Item No. **Report of the Head of Development Management and Building Control**

Address: 179A FIELD END ROAD RUISLIP

Development: Erection of a two-storey rear extension to provide storage and office space to existing shop

LBH Ref Nos: **78398/APP/2025/471**

**Scale** 1:100  
**Date** APRIL 2024  
**Drawing No.** 179/FER/020

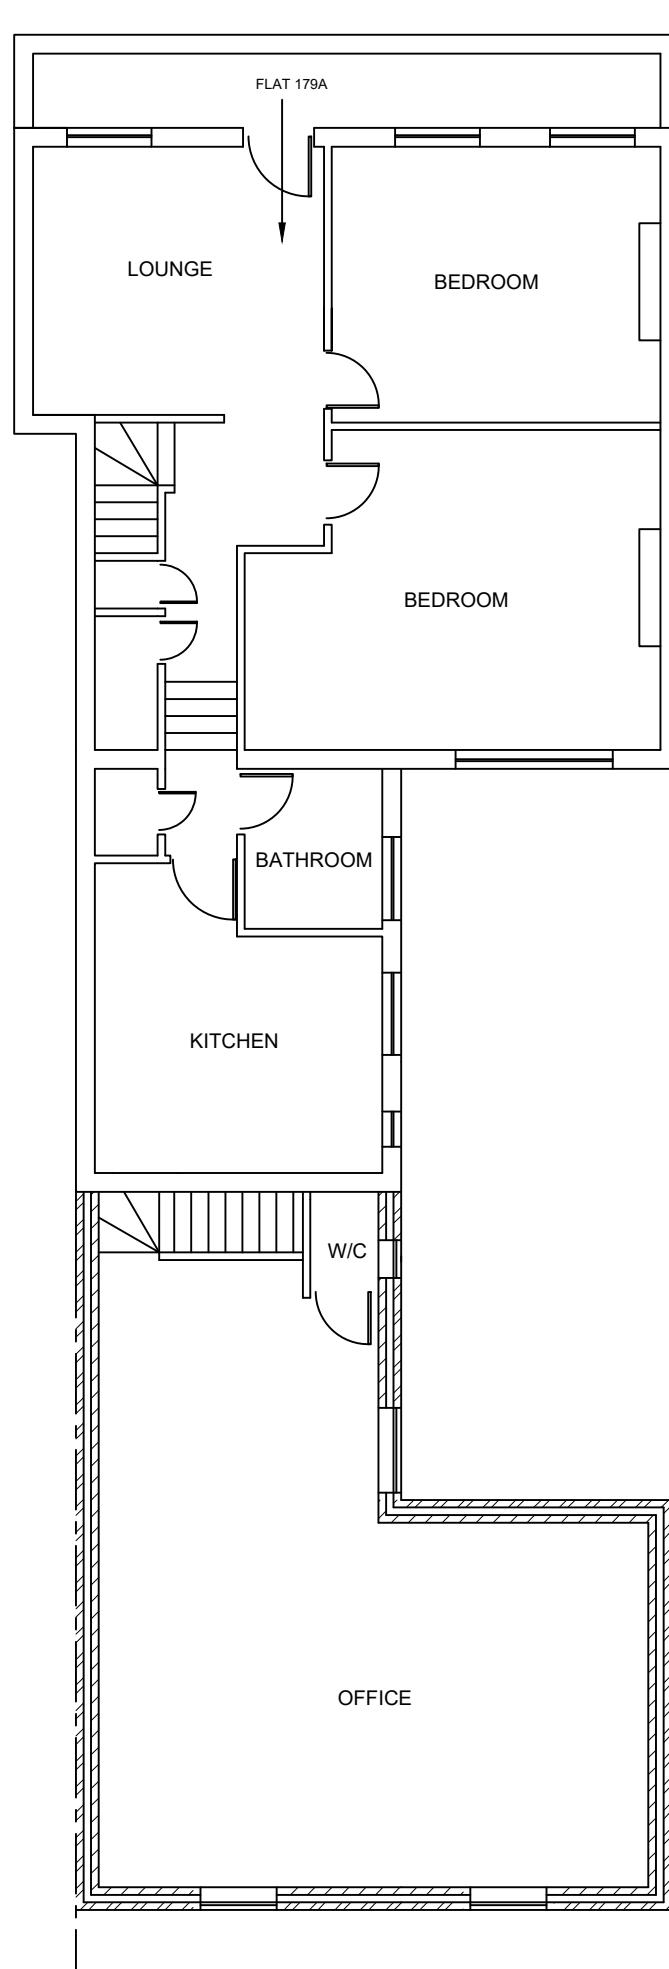
The proposed extension would be L-shaped at the first floor level and would be located approximately 9.7m from one of the flats within 179 Field End Road. The window within this flat would be the only habitable window within the kitchen/lounge and concerns are raised regarding the level of light and outlook this room would receive. Only a small top portion of the window would be visible from the rear elevation, with the majority obstructed by the wall built for the proposed first-floor extension.

The proposed two-storey rear extension would directly impact the outlook from three of the four habitable rooms serving No.177A. The extension would range from being 6.74 to 3.2m away from the southern face of No.177A. This would be significantly less than the expected standard of 21m of depth for outlook and would harm the sense of openness and spaciousness from the habitable rooms of the adjacent unit, and would increase their sense of enclosure. It would also cause harm to the privacy of No.177A due to overlooking from the north-facing first-floor window in the proposed extension into the habitable rooms of No.177A. The proximity of the proposed extension to the neighbouring habitable windows also raises concerns over access to daylight and sunlight for the habitable rooms of No.177A. The applicant has not provided a BRE daylight and sunlight assessment, which was identified as necessary under 78129/PRC/2024/96. Therefore the application has failed to demonstrate that the proposed development would not lead to an unacceptable loss of light or unacceptable overshadowing to No.177A.

The extension would impact the outlook from the front first-floor residential unit at 177B Field End Road. The extension would intrude within the 45-degree field of view from the first floor rear habitable window of the flat, resulting in a narrow corridor of only 3.2m in depth for outlook from the window. This would harm the sense of openness and spaciousness of the habitable room, increasing their sense of enclosure. It also raises concerns over access to daylight and sunlight in the habitable room. The applicant has not provided a BRE daylight and sunlight assessment, which was identified as necessary under 78129/PRC/2024/96. Therefore, the application has failed to demonstrate that the proposed development would not lead to an unacceptable loss of light or unacceptable overshadowing to No.177B.

The extension would impact the outlook from the existing front first-floor residential unit above 179A Field End Road. The extension would restrict the extent of outlook from the rear bedroom window to 9.6m in depth. This would harm the sense of openness and spaciousness from the habitable room for future occupiers of the existing unit.

The extension would impact the outlook from the front first-floor residential unit at 181A Field End Road located to the south of the application site. The extension would intrude within the 45-degree field of view from the first floor rear habitable window of the flat. This would harm the sense of openness and spaciousness from the habitable room, and would increase their sense of enclosure. This also raises concerns over access to daylight and sunlight for the habitable room of the neighbouring residential unit. The applicant has not provided a BRE daylight and sunlight assessment, which was identified as necessary under 78129/PRC/2024/96. Therefore, the application has failed to demonstrate that the proposed development would not lead to an unacceptable loss of light or unacceptable overshadowing to No.181A.

The application proposes erecting an L-shaped 9.5m deep two-storey rear extension ranging from 4.3m to 7.9m in width. The extension would be approximately 5.6m high to match the existing rear facade of the building and would have glazing facing internally to the site and the rear access street. The extension would be constructed out of unspecified bricks and would have a flat roof.
